Your ref: N6/2010/2055/MA
Our ref: E/WH/2010/22105/N/340

FULL PLANNING PERMISSION FOR PART DEMOLITION, REPAIR, RESTORATION, EXTENSION AND CONVERSION OF THE FORMER SHREDDED WHEAT FACTORY COMPLEX TO PROVIDE RETAIL (A1 & A3), BUSINESS (B1), HERITAGE CENTRE (D1), ENERGY CENTRE, NEW LEISURE CENTRE BUILDING AND CIVIC SQUARE BUILDING INCLUDING RESIDENTIAL AND RETAIL (A1 TO A5). ASSOCIATED ALTERATIONS TO EXISTING VEHICULAR AND PEDESTRIAN ACCESS AND HIGHWAY LAYOUT WITHIN AND AROUND THE SITE, INCLUDING THE CREATION OF TWO VEHICULAR ACCESS RAMPS TO BASEMENT PARKING, HARD AND SOFT LANDSCAPING, THE PROVISION OF A CIVIC SQUARE, PARK, PUBLIC AND PRIVATE OPEN SPACE, PEDESTRIAN WALKWAYS TO INCLUDE THE UPGRADE OF THE EXISTING PEDESTRIAN FOOTPATH OVER THE RAILWAY LINE AND ASSOCIATED ENABLING WORKS. OUTLINE PLANNING PERMISSION FOR DEVELOPMENT OF LAND TO THE WEST AND SOUTH OF THE SHREDDED WHEAT FACTORY TO COMPRISE THE FOLLOWING USES: RETAIL (A1 & A5), BUSINESS (B1), HOTEL (C1), RESIDENTIAL, TO INCLUDE: HOUSES, FLATS, CARE HOME AND YMCA (C2 & C3); DOCTORS SURGERY AND PHARMACY (D1); WITH ALL MATTERS RESERVED APART FROM MEANS OF ACCESS - FORMER SHREDDED WHEAT FACTORY COMPLEX AND LAND ADJOINING, ROADWATER

BROADWATER ROAD WEST, WELWYN GARDEN CITY  
 DETAILED PROPOSALS: LEISURE CENTRE (BUILDING A)  
 PROPOSED PLANS  
 568\_07\_210

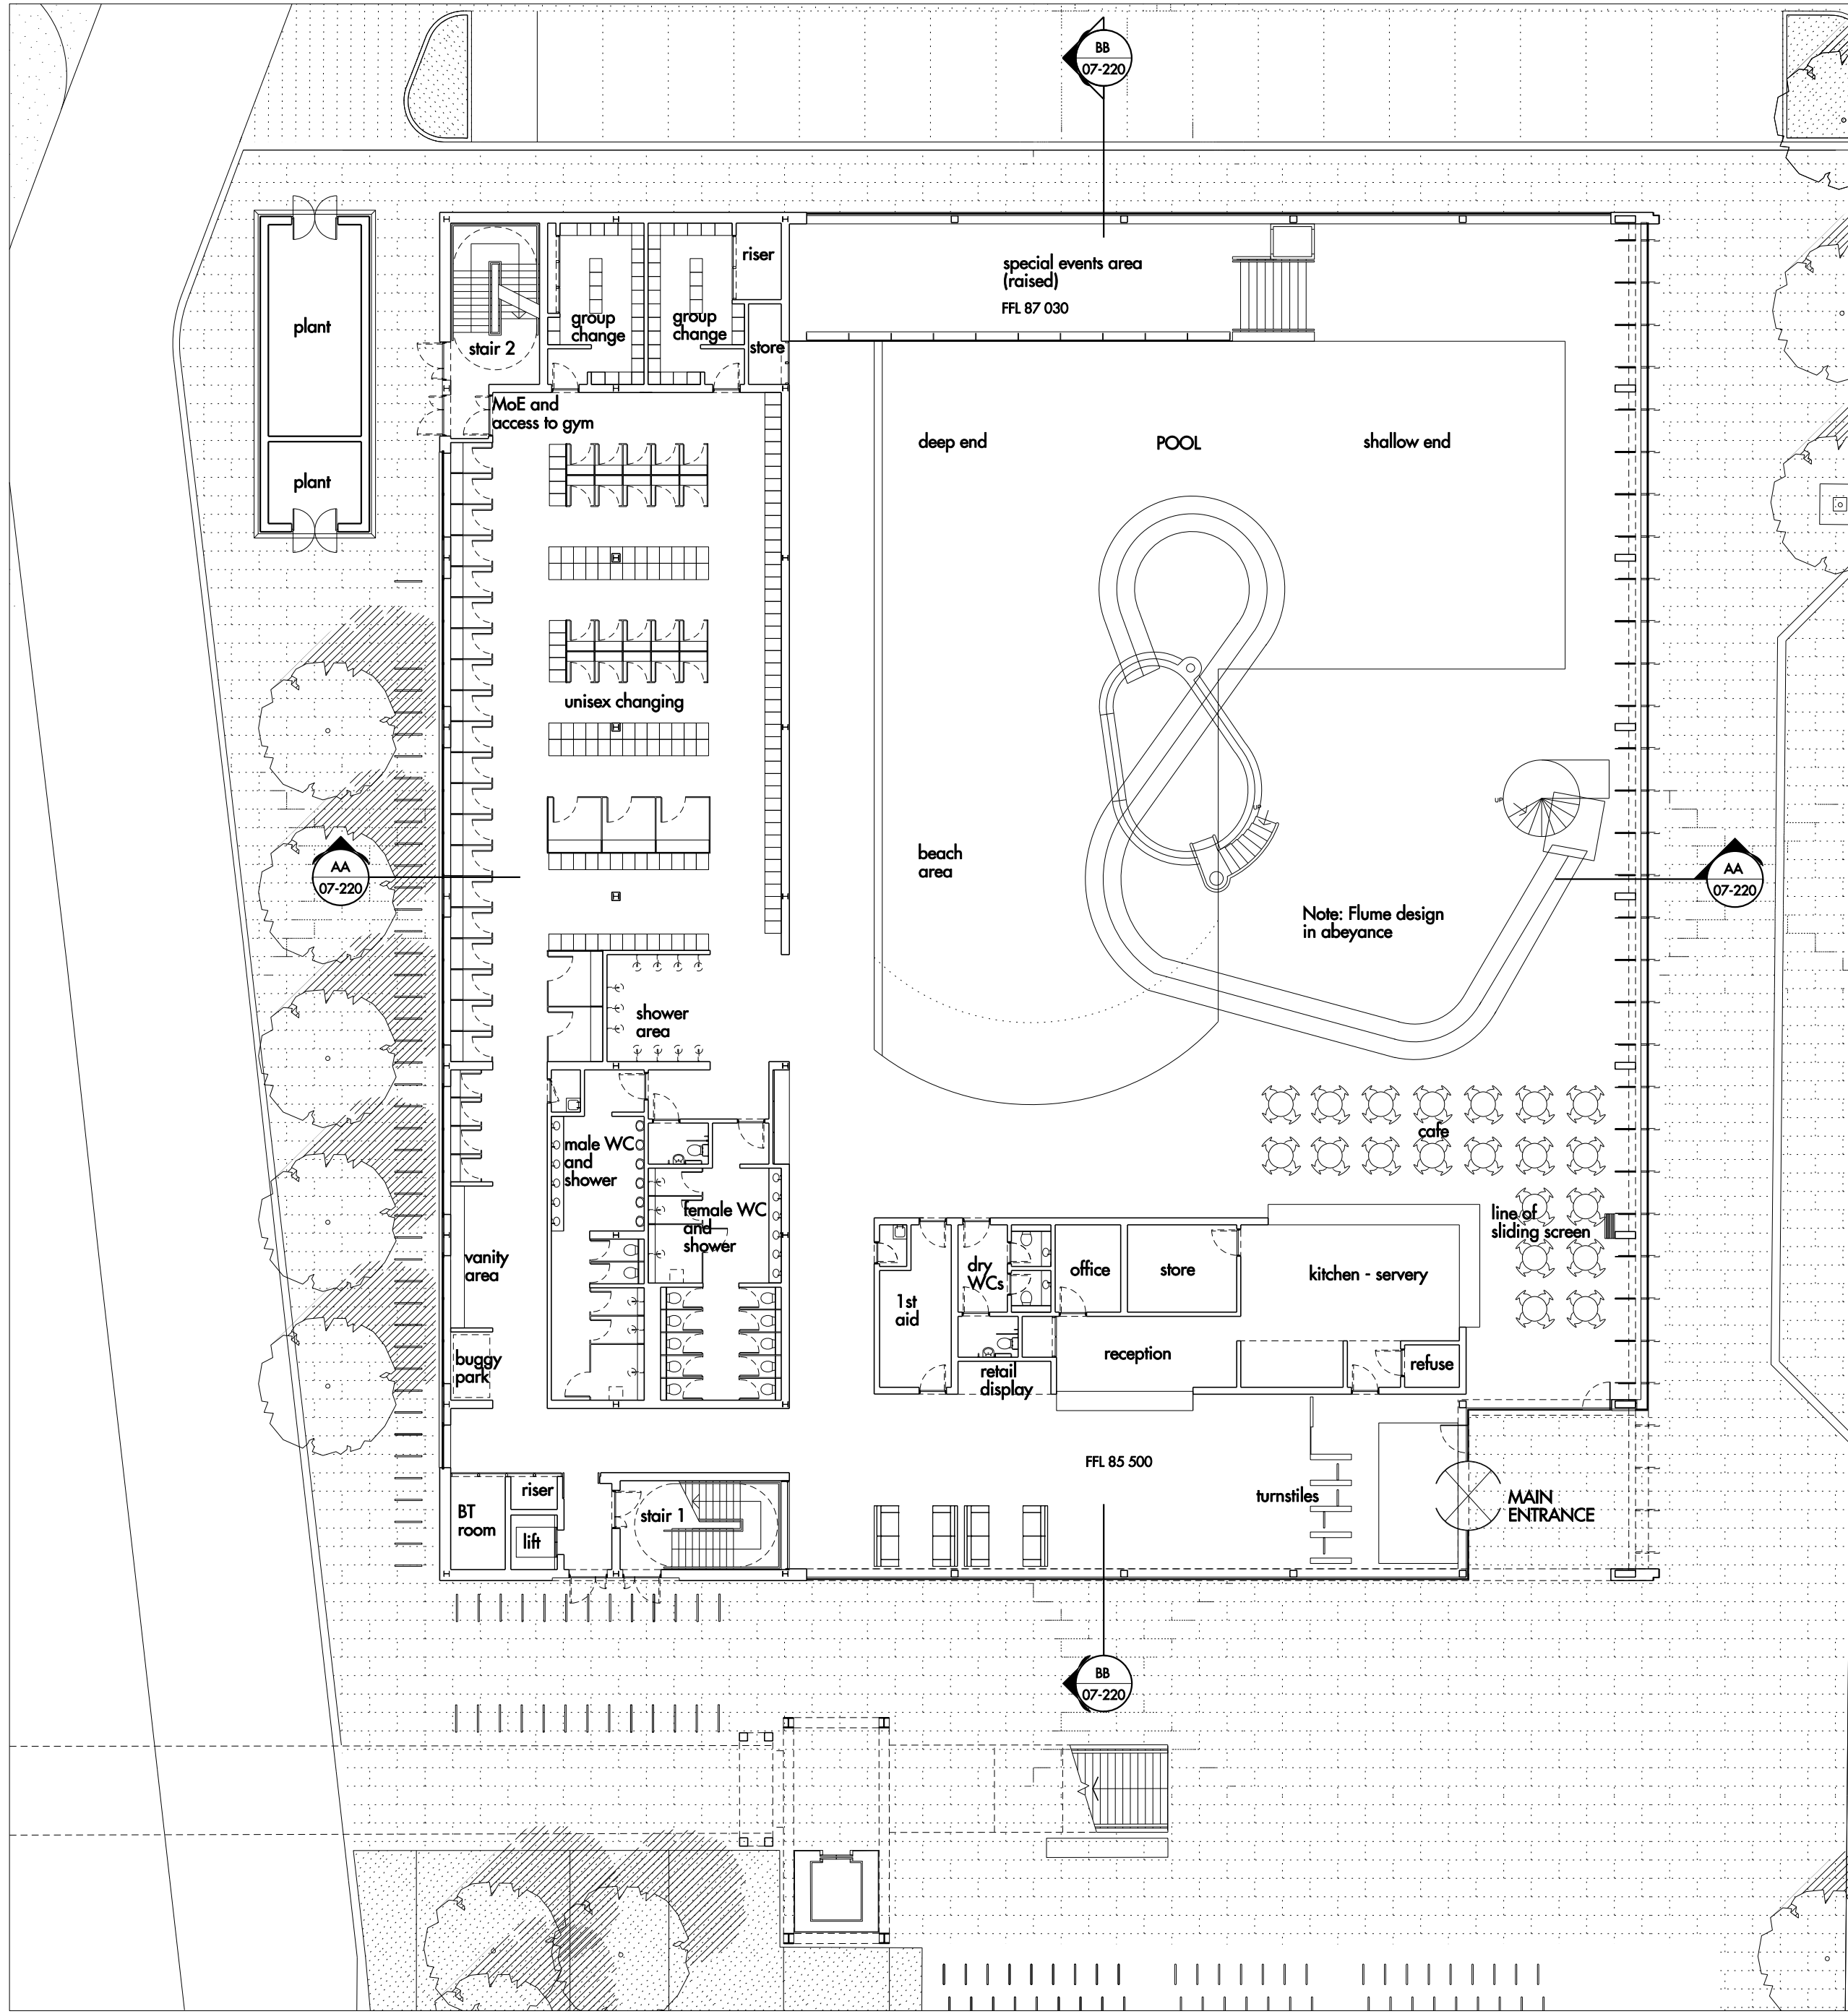
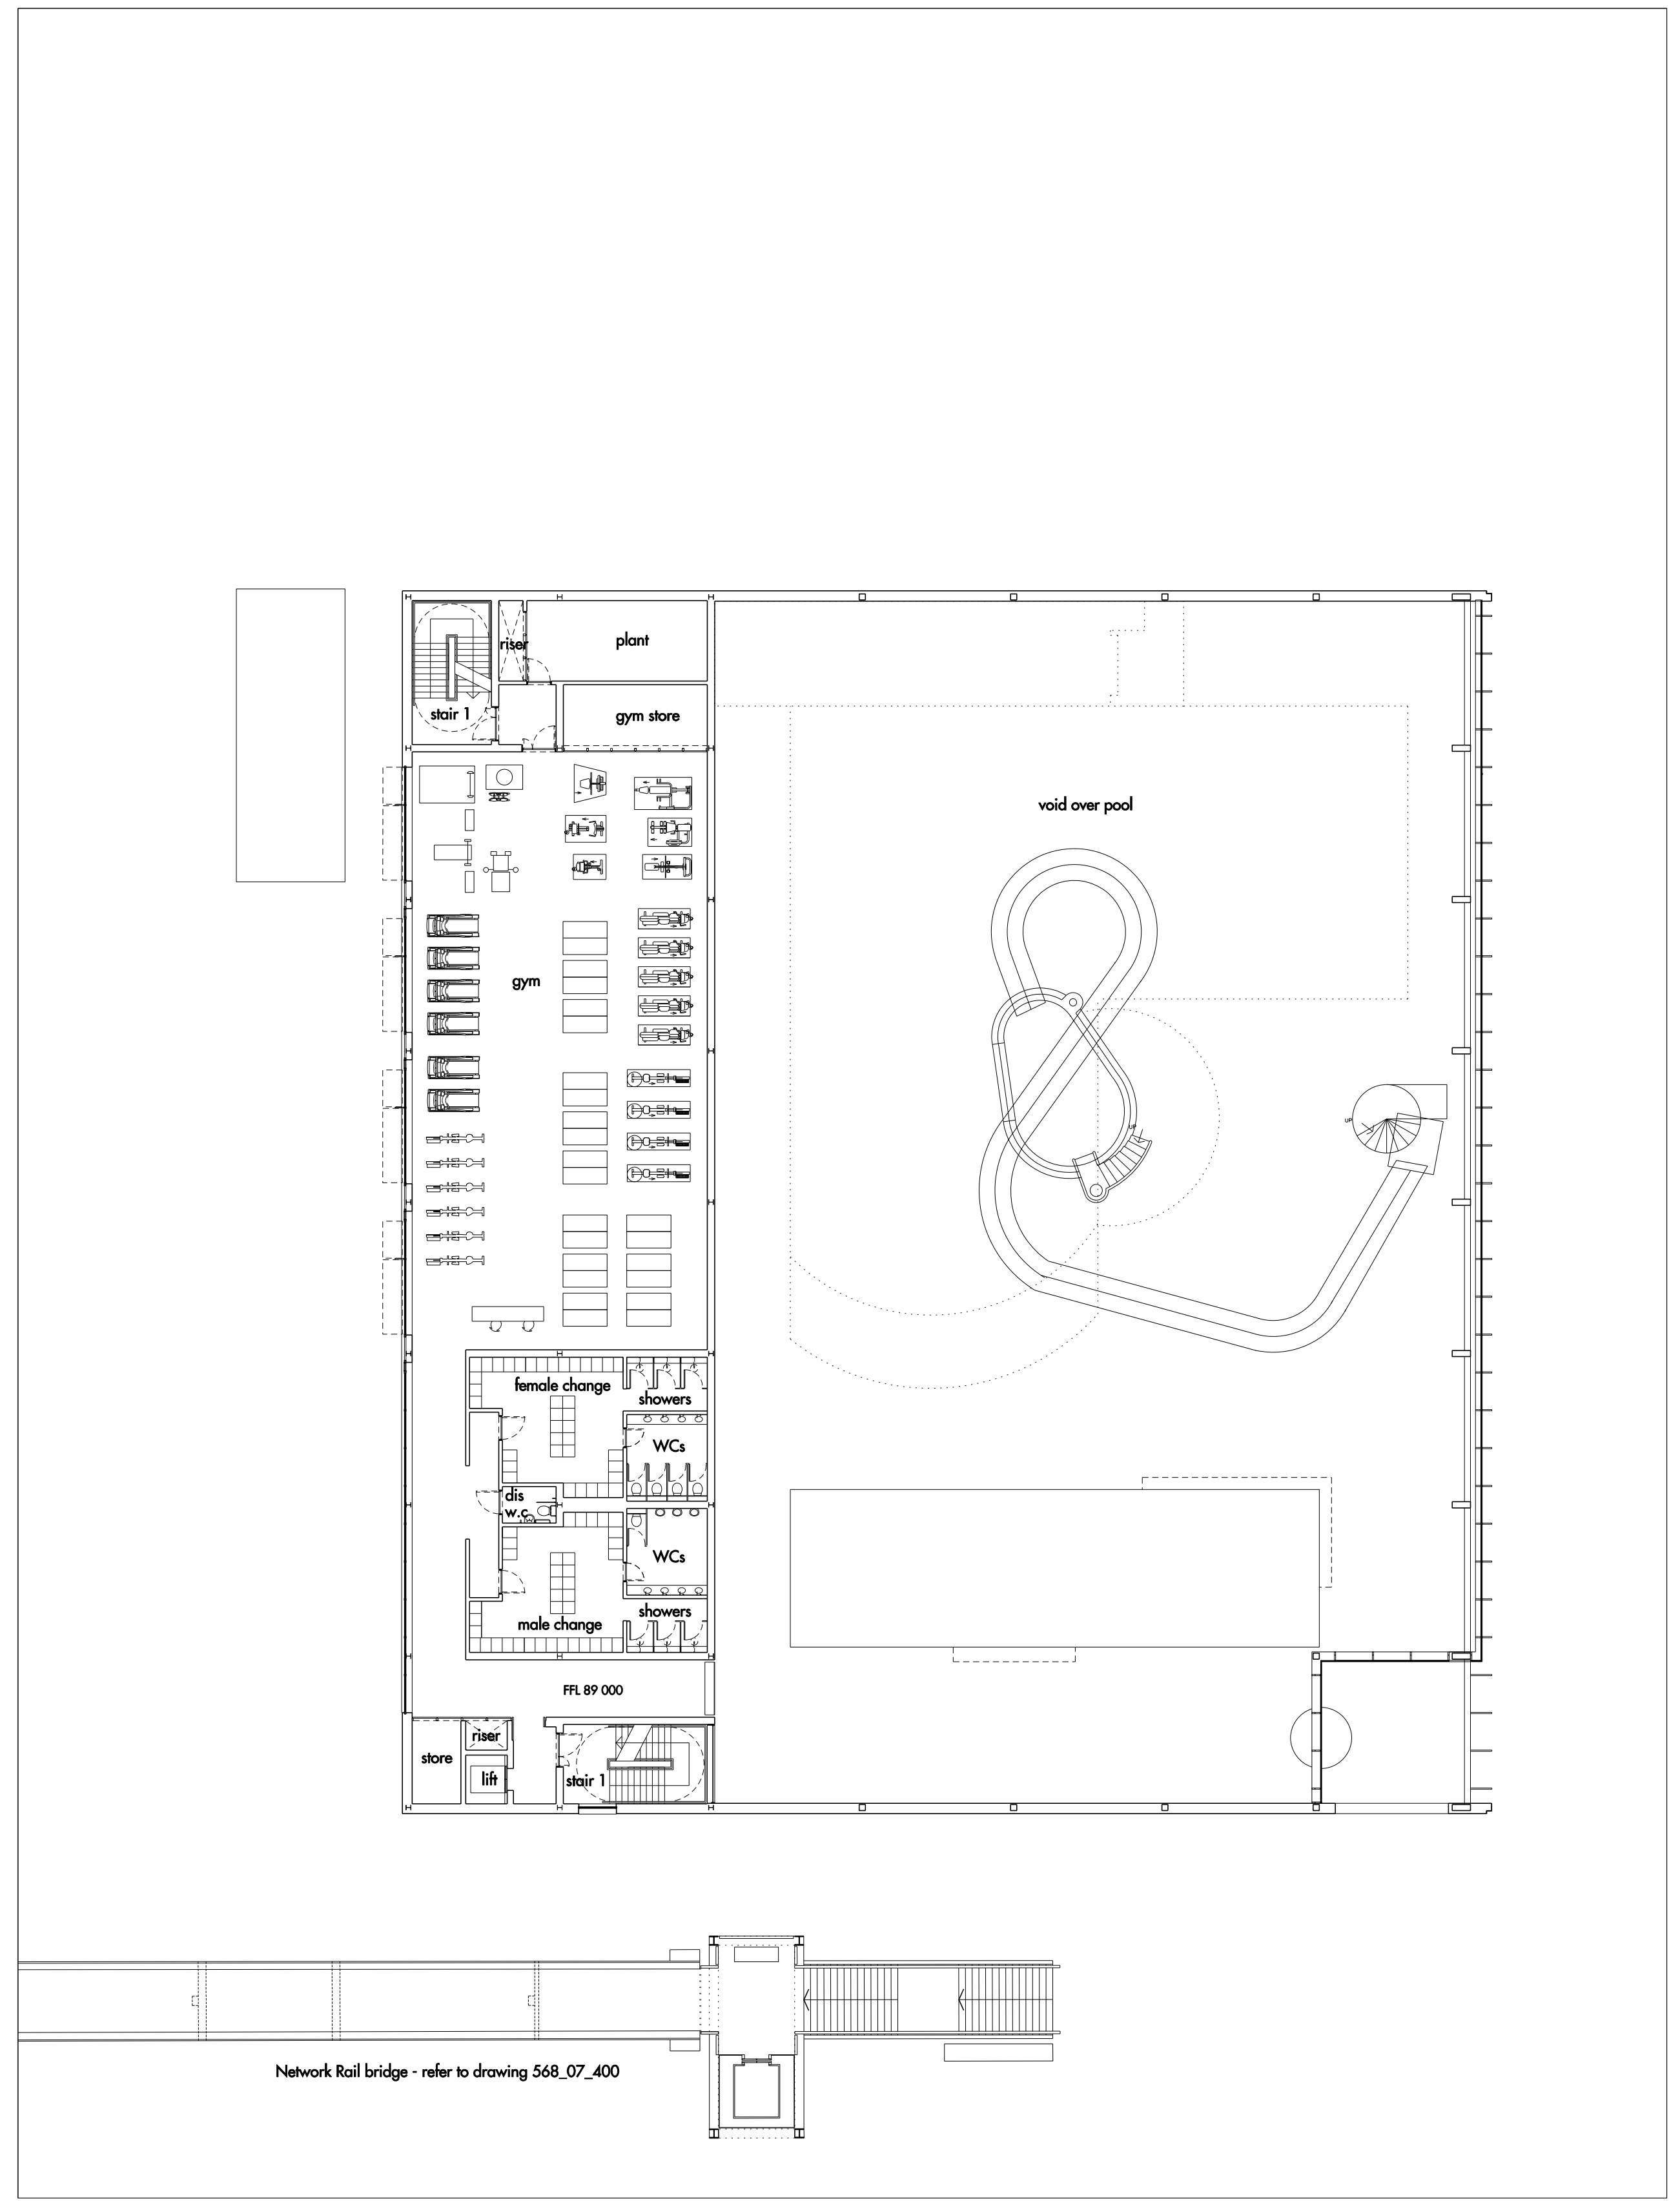
- Sport England promote the use of a draft lobby at the main entrance to aid the reception environment.
- The turnstiles would normally be post reception, in order to allow access to the reception whilst also maintaining control of access to the building
- It is recommended that the first aid room has a direct exit to the outside so that a casualty can be loaded directly into the ambulance. This would require a change of location.

- The pool is currently designed to accommodate both lane and leisure swimming – does this reflect local need? Can the pool deliver on the learn to swim priorities that may be required locally through educational need and community need with the current design?

- If the swimming pool is to remain as proposed it is suggested that the swimming pools would benefit from being the other way round i.e. with the 25m run being parallel to the changing rooms (shallow end at the entrance end). This will allow people that bring other people to learn to swim classes to be able to observe what is happening from the seating in the café area.

- In relation to the 25m section of the pool the flume should be moved so it does not go over this at all (it is thought that there is room to achieve this) and the raised section (labelled events) at the deep end should remain at a similar level (deck level) all around the swimming pool – both of these points relate to access and sight lines for staff, particularly when the swimming pool is in use for club/teaching, when good contact between staff on the poolside and those in the water is required

- The proposed width of the 25m section of the pool is 12m. Sport England's Swimming Pool Design guidance document (referenced above) recommends that the width of a 6 lane pool should be 13 metres wide while the width of a 5 lane pool should be 10.5 metres

- It would appear that spectators are encouraged to be on poolside and use toilets that lead from the pool surround. It can not be understood from the detail provided how these areas are separated (if at all) but this would encourage contamination, as would the food serving area, into the wet side if not carefully managed

- Changing spaces – the current level of provision is 94 plus group change. Based on the volume of water space provided approximately 190 change spaces are needed to cope with average demand. This is based on the calculation model identified in the guidance (link provided above). This needs to be considered alongside the programming of the facility to feel confident that any final proposals can accommodate user numbers.

- Toilets - In terms of toilet provision, the current level of provision is 13 WC's and 6 urinals. For the amount of water space proposed 10 WC's and 6 urinals are required.

- Showers – currently 17 are provided, this could be rationalised to 12 to 14. It is recommended that all showers are provided in central areas and not within toilet areas. This means that they

are accessible by all. It is advantageous to provide some of the showers are cubicle showers to aid privacy. Showers should be centrally located to facilitate both pre and post swim usage.

- An accessible change is required in wet side area.

- An accessible change is required in dry side and not just a toilet.
- In terms of layout this is not ideal. The toilets should be accessed first. This allows those users who are not getting changed to access the toilets. This then leads to the change area with showers at the rear. With the current proposed layout anyone wishing to use the toilet will have to access the change

- In terms of capacity, the usable space in each is around 34 (this is presuming that each square within the changing rooms on plan Detailed Proposals: Leisure Centre (Building A) Proposed Plans (568_07_210) are changing spaces as apposed to lockers). 1 change space per gym station or 1 change space per 5 sqm of gym floor space are the recommended ratios. The proposed dry side changing areas therefore currently represent an over provision

- There are currently 6 showers proposed. 1 shower per 6 change spaces is the recommended ratio. The proposed provision of showers therefore currently represents an under provision (as mentioned above, this is presuming that each square within the changing rooms are changing spaces as apposed to lockers)

- Lockers – these can be provided within the change area or outside. It is recommended to provide small valuables lockers externally to facilitate those not using the change area. Lockers should not be provided behind the changing spaces as this compromises access at peak time. There should be 2.5 lockers per change space to allow for change overs and a number of lockers being out of use. Accessible lockers need to be provided outside of the accessible change

- Natural light should be encouraged whilst avoiding glare
- Views over the pool should be included where appropriate (whilst being aware of child protection issues)
- A plumbed in water fountain should be included to serve the gym

- The toilet located on the second floor needs to be accessible

- There is significant office space on the second floor. This may be useful for centre and local club usage but this needs to be clarified as it is a significant expense to the scheme.
- In relation to the long term sustainability of the proposed Leisure Centre to may be useful to consider the mixture of facilities included i.e. would the inclusion of a larger gym or a dance studio be beneficial from a revenue generation perspective?
